Medworth Energy from Waste Combined Heat and Power Facility

PINS ref. EN010110
Document Reference Vol.12.3
Revision: 1.0
Deadline: 4
May 2023

Applicant's comments on the Deadline 3 Submissions: Part 1 Statutory Parties

**Figure 10.1iii**  
**New Bridge Lane access proposal**

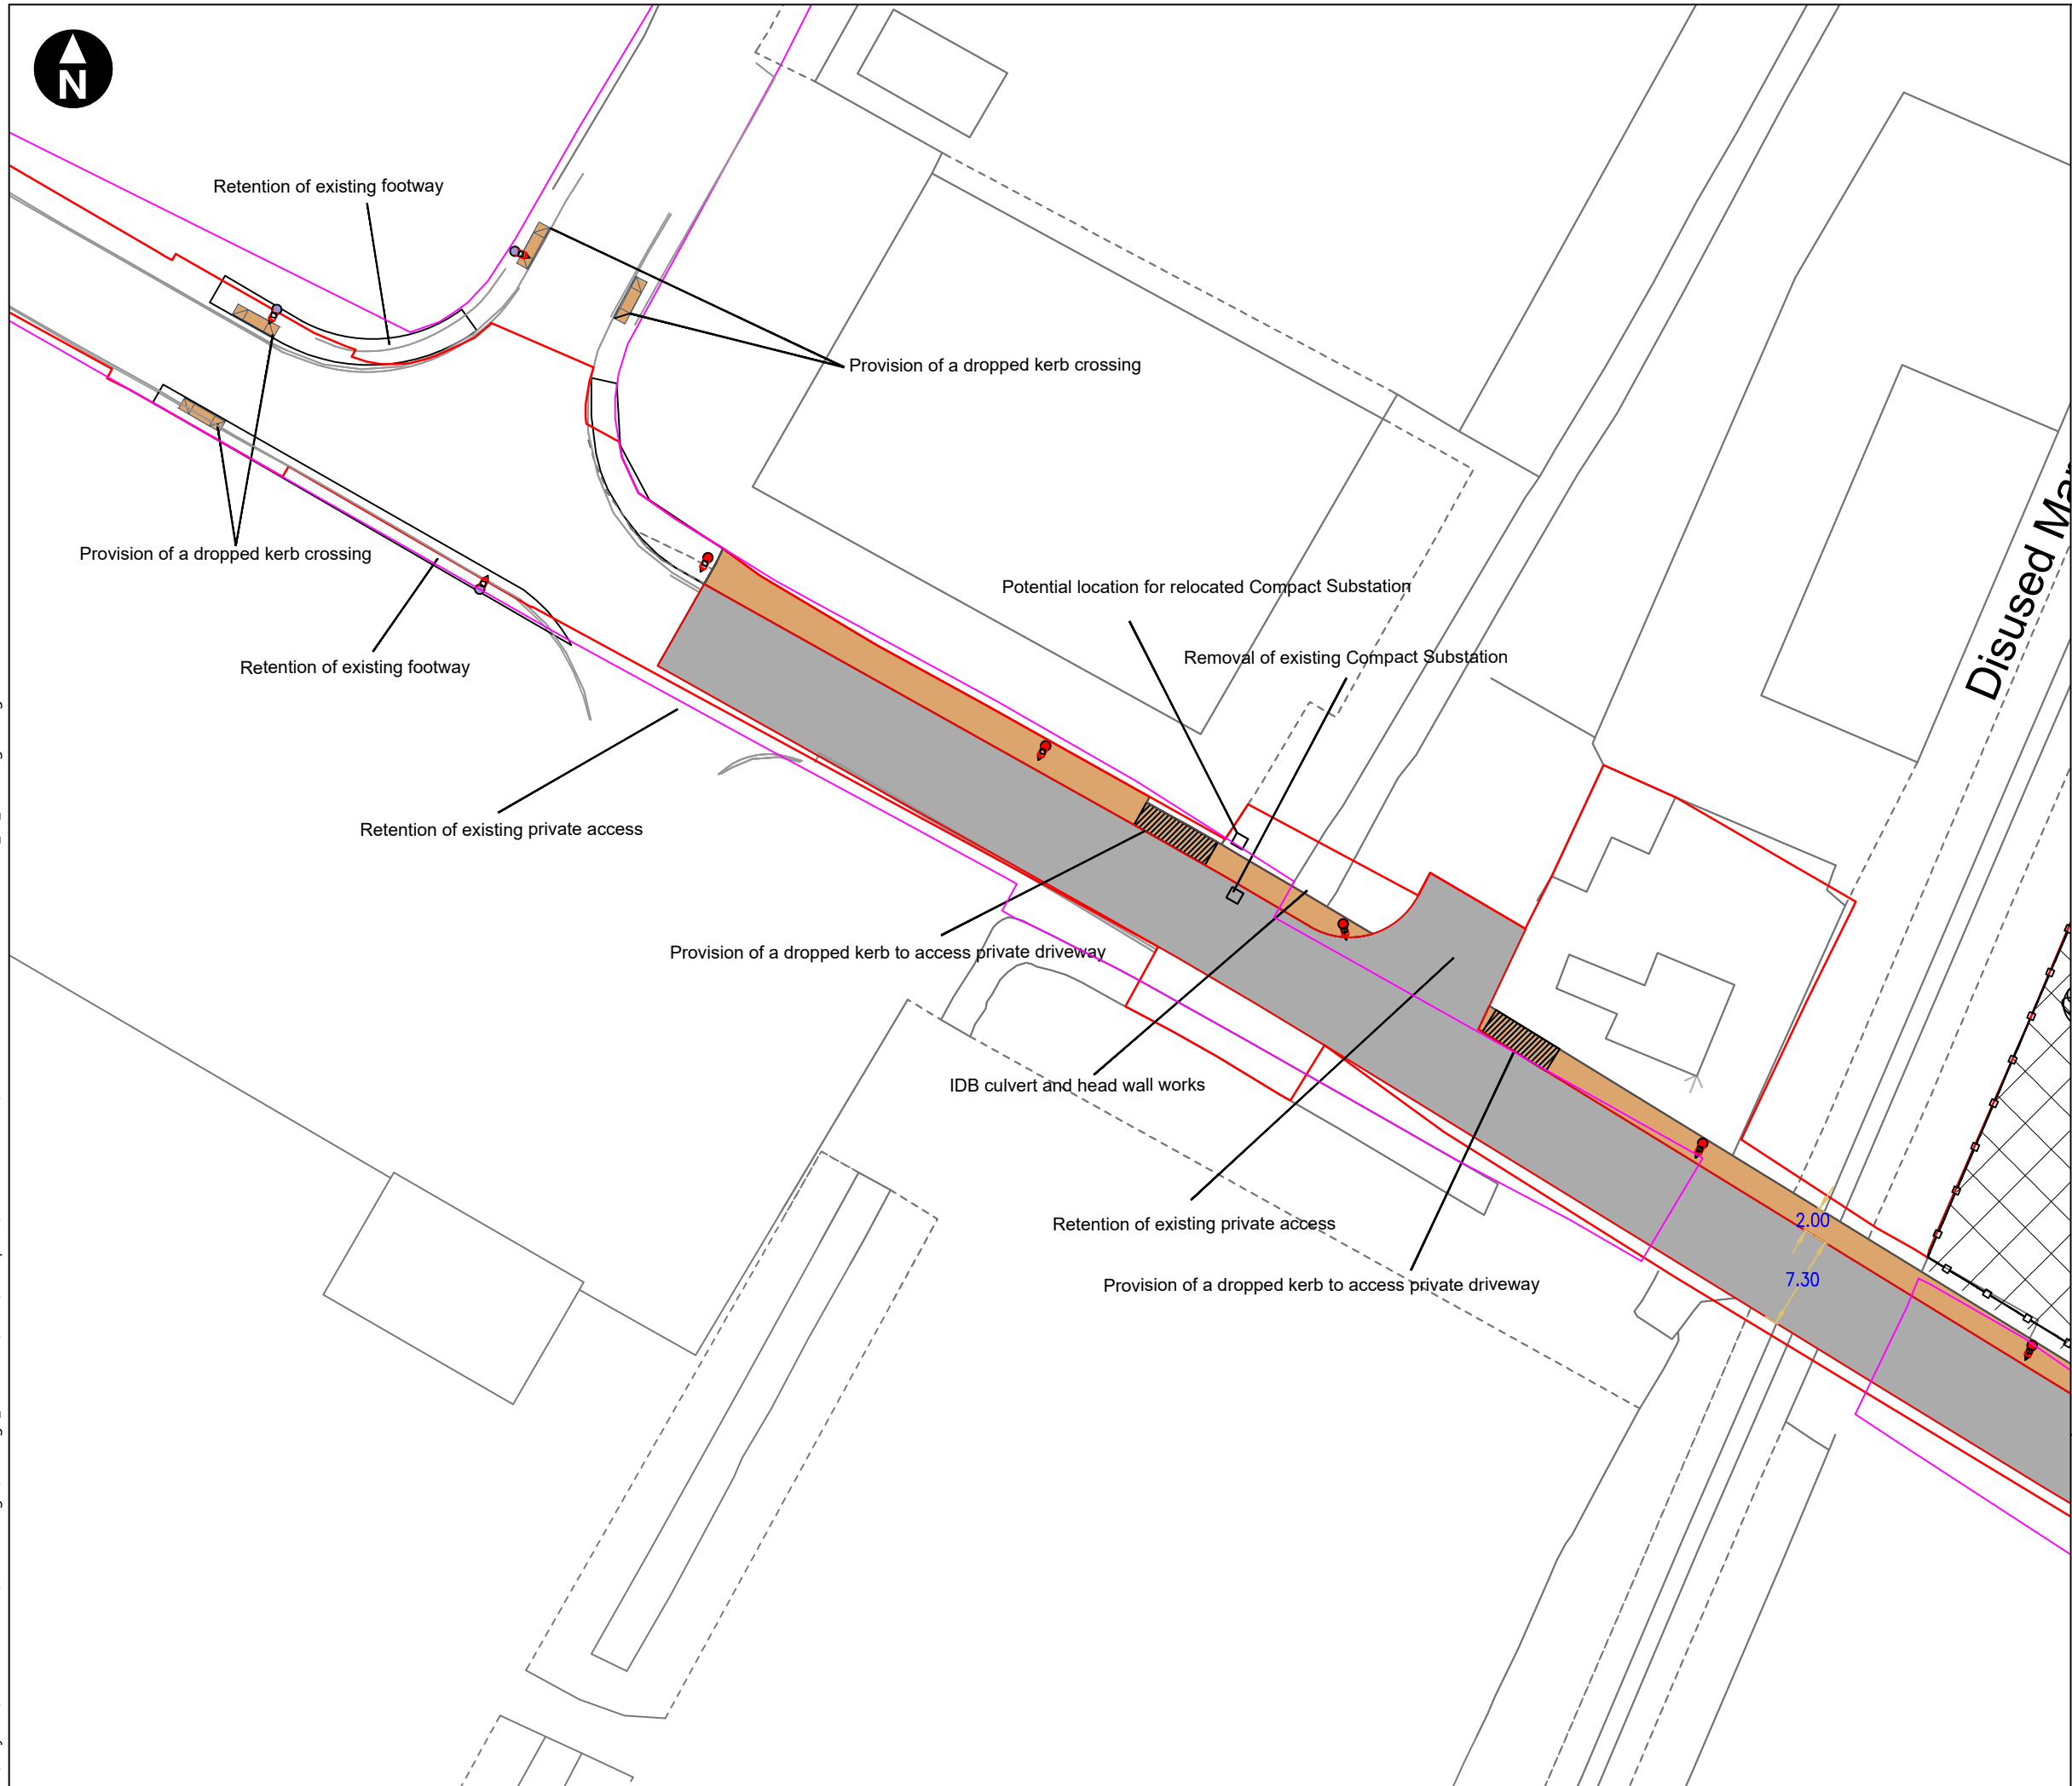
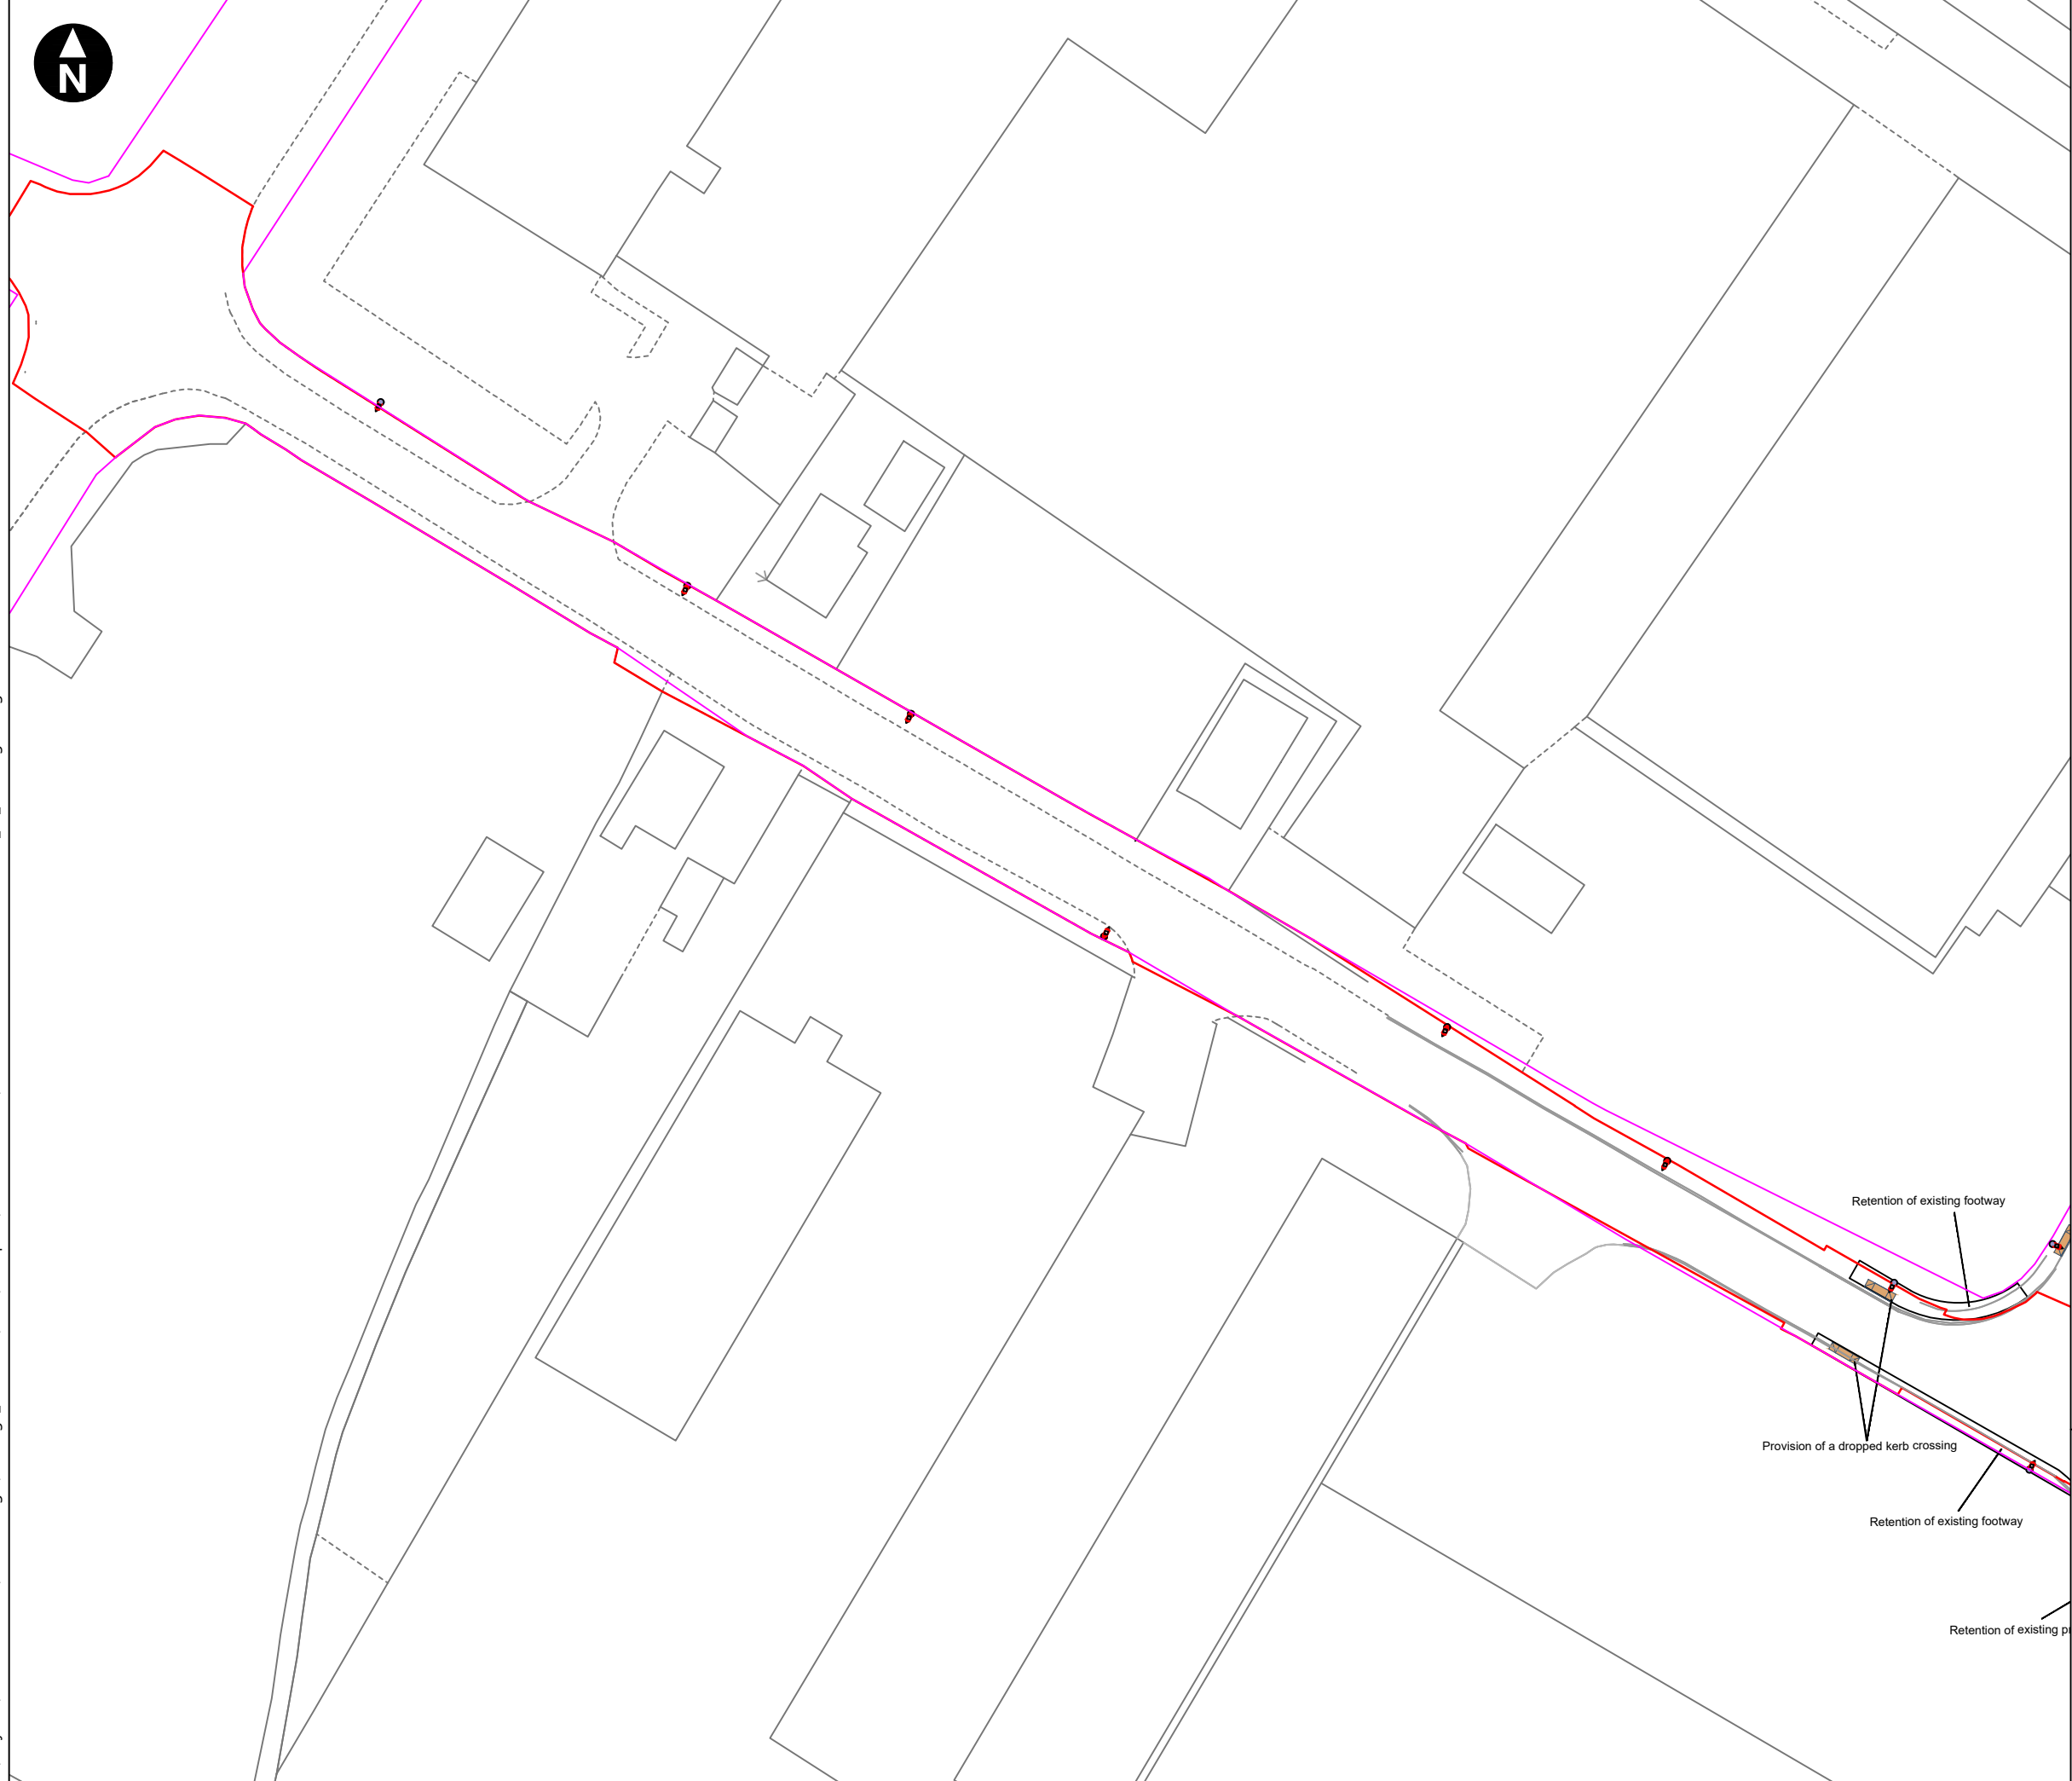
<p>30mph speed limit proposal for New Bridge Lane 2.7.23</p>	<p>The Applicant's proposal to reduce the speed limit on the area of New Bridge Lane affected by its works is welcomed. However, there are currently no clauses in the draft DCO which introduce the relevant traffic regulation measures to alter the speed limit. Including such measures in the draft DCO would provide clarity to the public over the Applicant's intentions and would circumvent the requirement to undertake a separate order-making process to alter the speed limit. Any requirement to complete separate order-making processes may impact on the timescales for delivery of other elements of the proposed works.</p>	<p>The Draft DCO [REP3-007], submitted at Deadline 3, includes at article 17(f) the express power to impose a 30 mile per hour speed limit over New Bridge Lane.</p>
